CITY OF ALBUQUERQUE

November 22, 2017

**RE: Country Club Plaza Bldg 3
Conceptual Grading and Drainage Plan
Engineers Stamp Date: 11/17/17
Hydrology File: J13D010**

PROJECT  
Country Club Plaza | Building 3  
1716 Central Avenue SW  
Albuquerque, NM 87104  
TITLE  
CONCEPTUAL GRADING & DRAINAGE PLAN

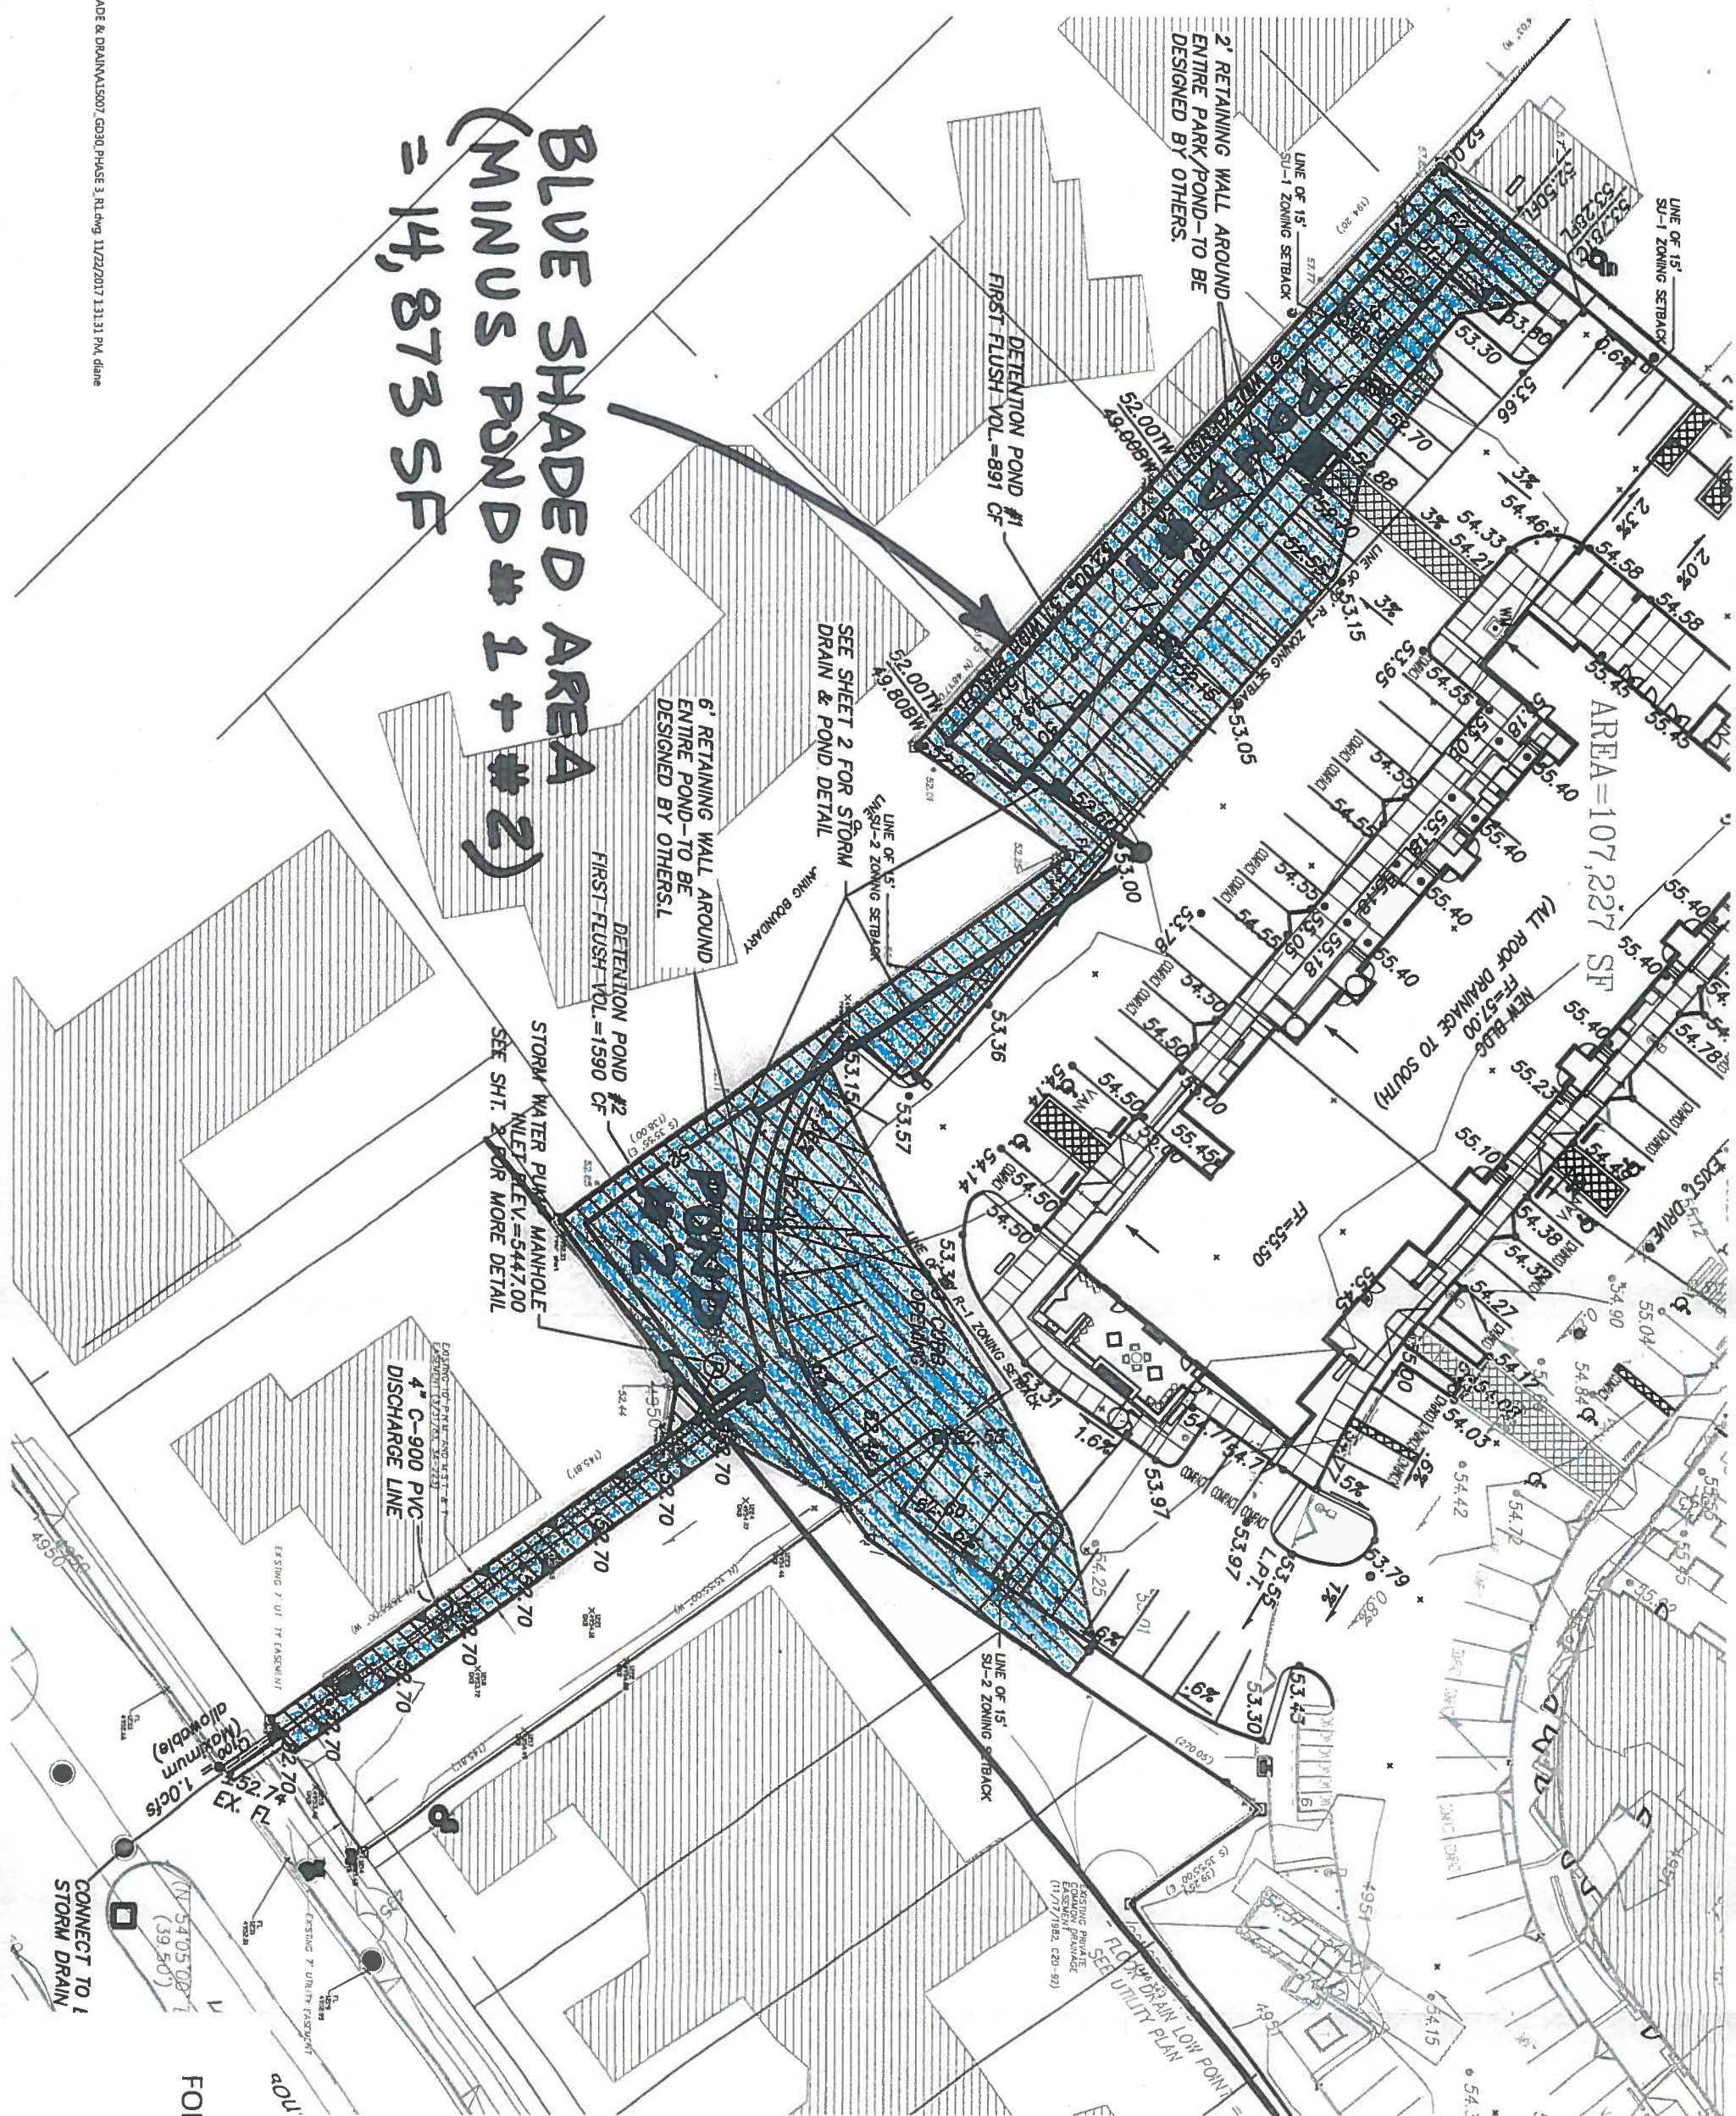
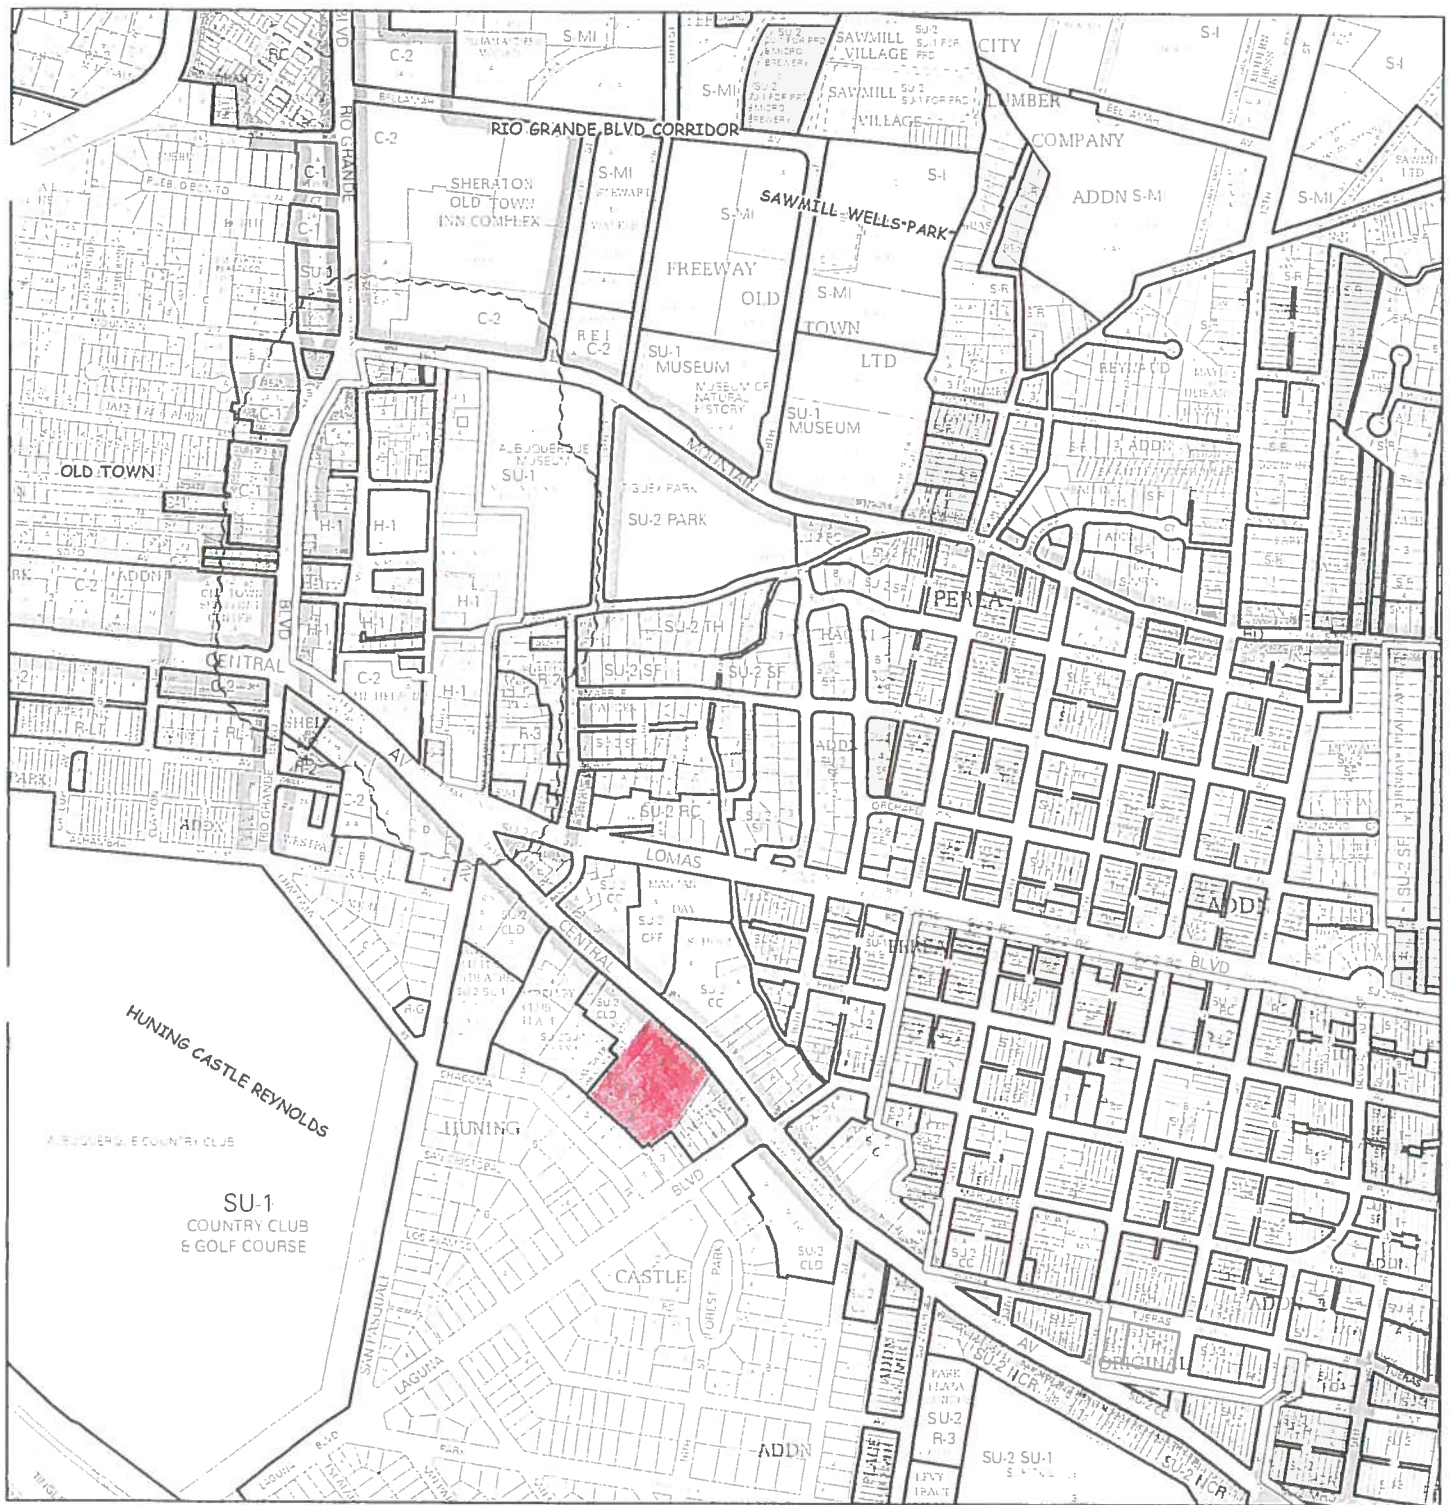
1. Demonstrate that if the pump fails, the 100-year, 10-day volume will not flood the adjacent properties. i.e.: determine this water surface elevation and show that it will either remain on the Country Club Plaza property or flow overland out to Laguna. Provide section views across the property line as required to support this.
